Located At 363 DEERING AVE

has permission to build a New Single Family Residence with an Attached Garage.

**Jonathan Rioux - Re: 363 Deering Ave.**

On Apr 20, 2012, at 2:07 PM, Jonathan Rioux wrote:

Mark	Date	Description
Checked By		Project No. 10185
Drawn By	JPG	Drawing Code
Project Phase	FINAL DESIGN	
Scale	AS NOTED	Date 01.31.2012
Sheet Title	STRUCTURAL NOTES	
Drawing No.	S0

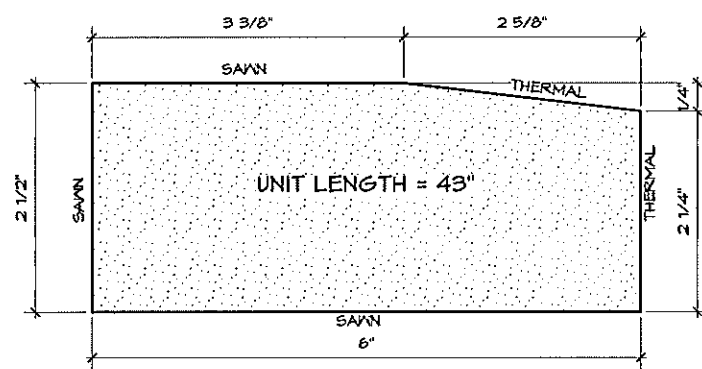
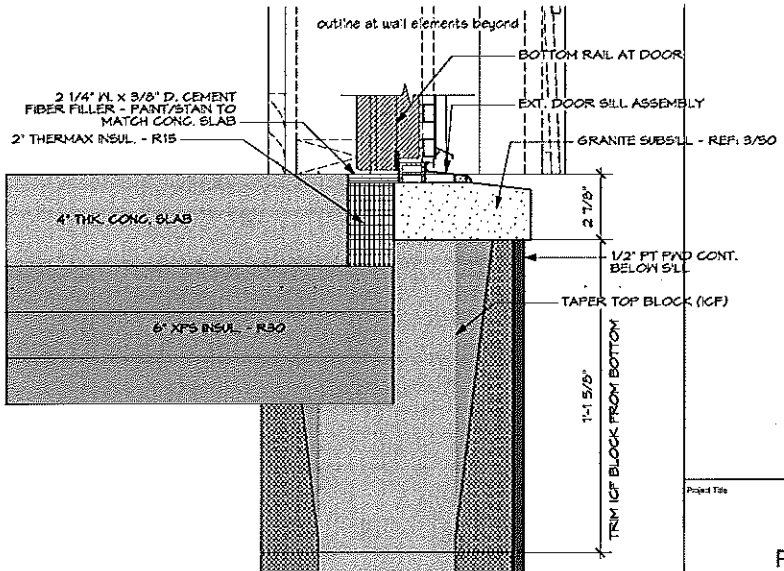
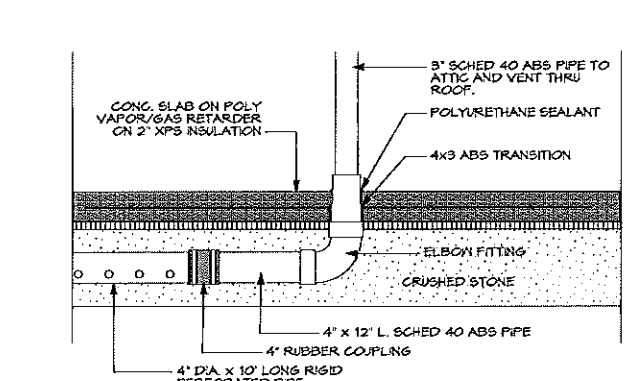
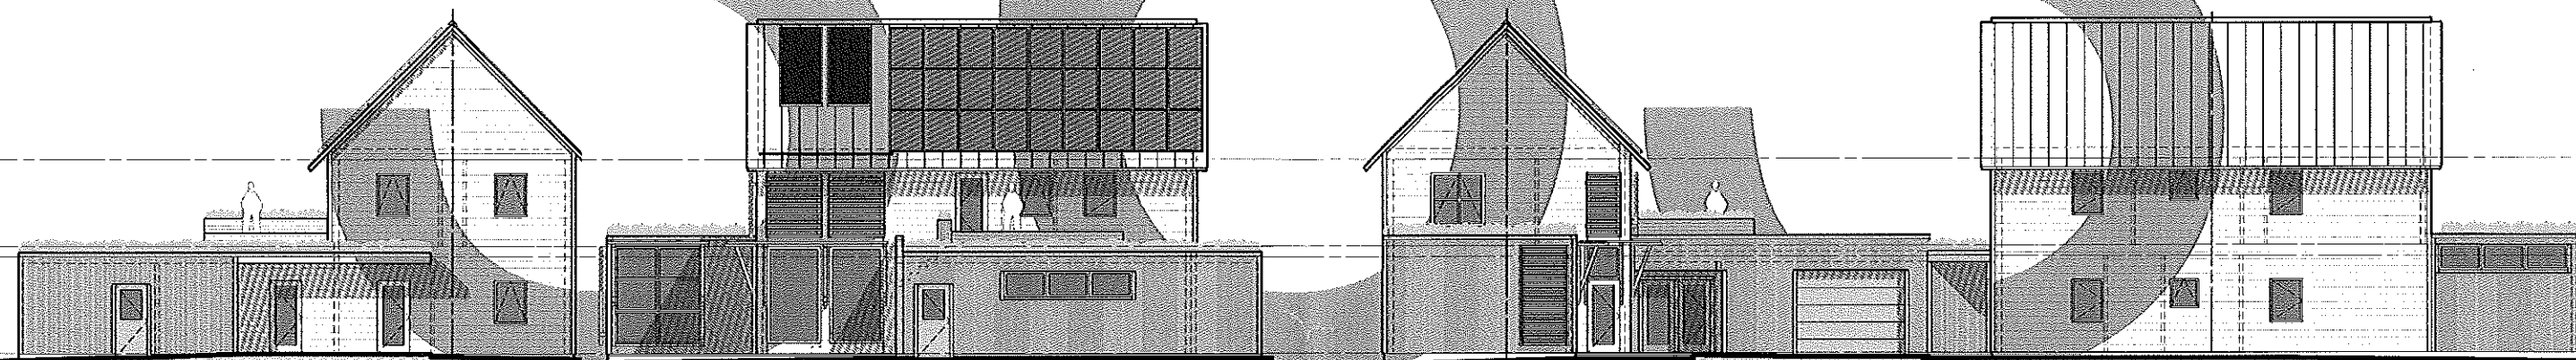
- Provide specifications for Engineered Trusses & ICF Additional specifications/notes have been added to sheet S0-REV (please see attached).
- Are the Trusses designed to support each Solar Panel? Yes. Please see note re: Solar Panels on attached sheet S0-REV.

A1.1

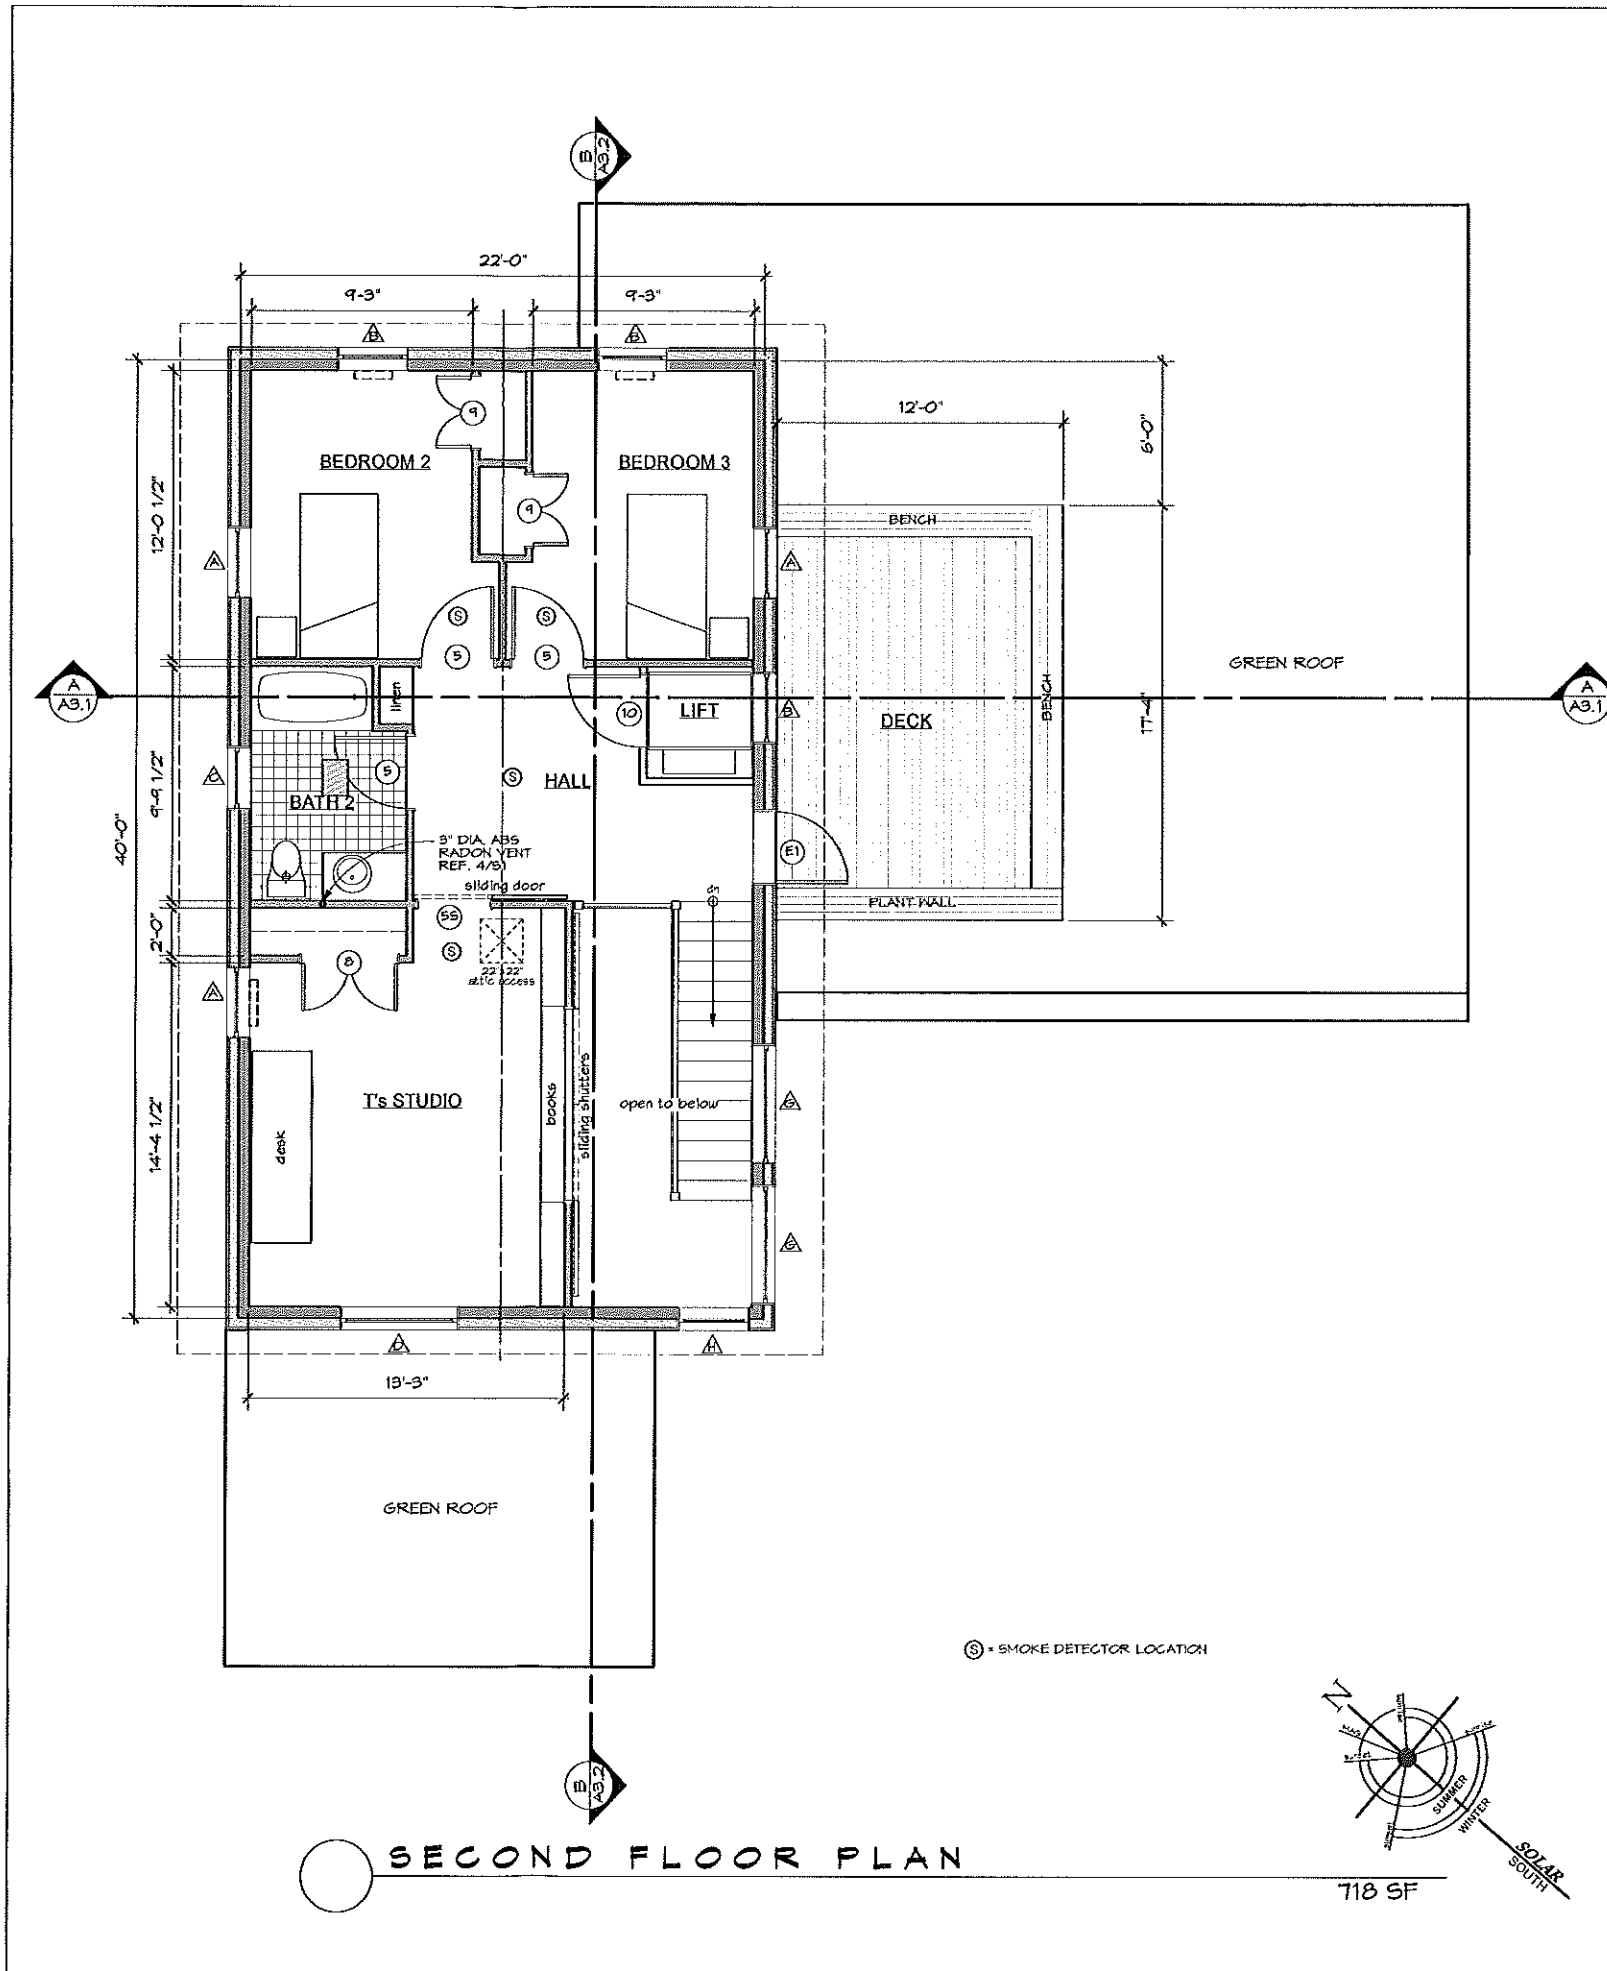
- A Carbon Monoxide (CO) alarms shall be installed in each area within or giving access to bedrooms. That detection must be powered by the electrical service (plug-in or hardwired) in the building and battery. One smoke detector at each floor has been changed to a combined Carbon Monoxide/Smoke Detector/Alarm device, hard-wired with battery back-up and interconnected. Please see attached drawings A1.1-REV and A1.2-REV.

Sheet Title
SECOND FLOOR PLAN

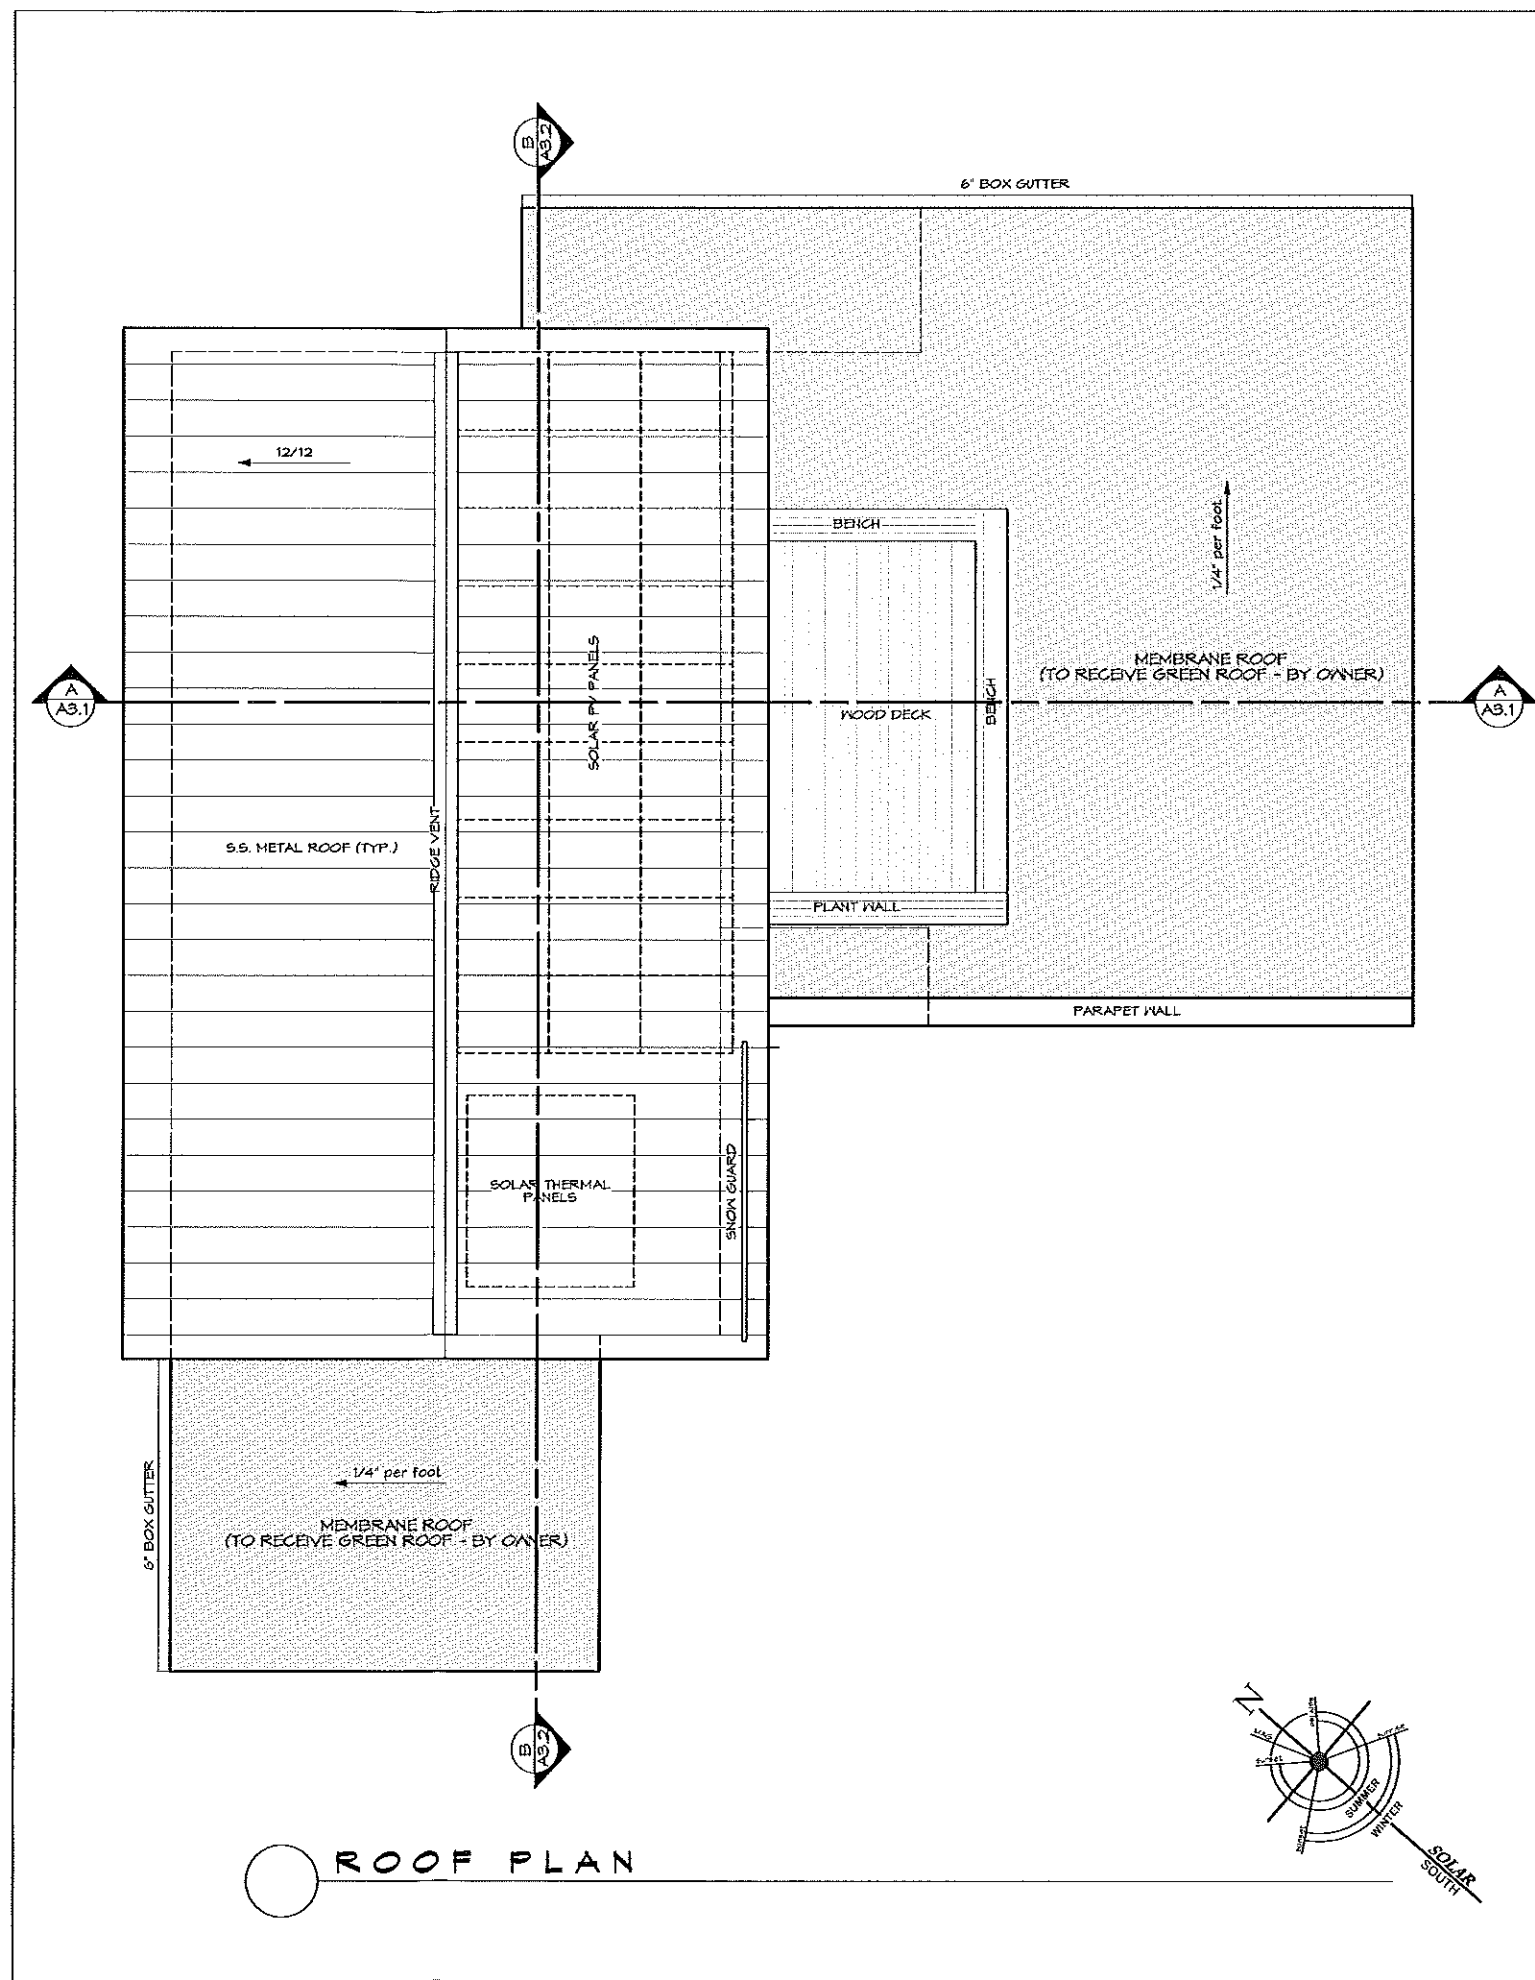
- Ventilation of Space per ASRAE 62.2, 2007 This house will be ventilated in full compliance with ASHRAE 62.2 via Heat Recovery Ventilation system.
- 22 by 22 inches show...R807.1 Attic access. Buildings with combustible ceiling or roof construction shall have an attic access opening to attic areas that exceed 30 square feet and have a vertical height of 30 inches or greater. The vertical height shall be measured from the top of the ceiling framing members to the underside of the roof framing members. The rough-framed opening shall not be less than 22 inches by 30 inches and shall be located in a hallway or other readily accessible location. I have revised the attic access to 22x30. Please refer attached drawing A1.2-REV.
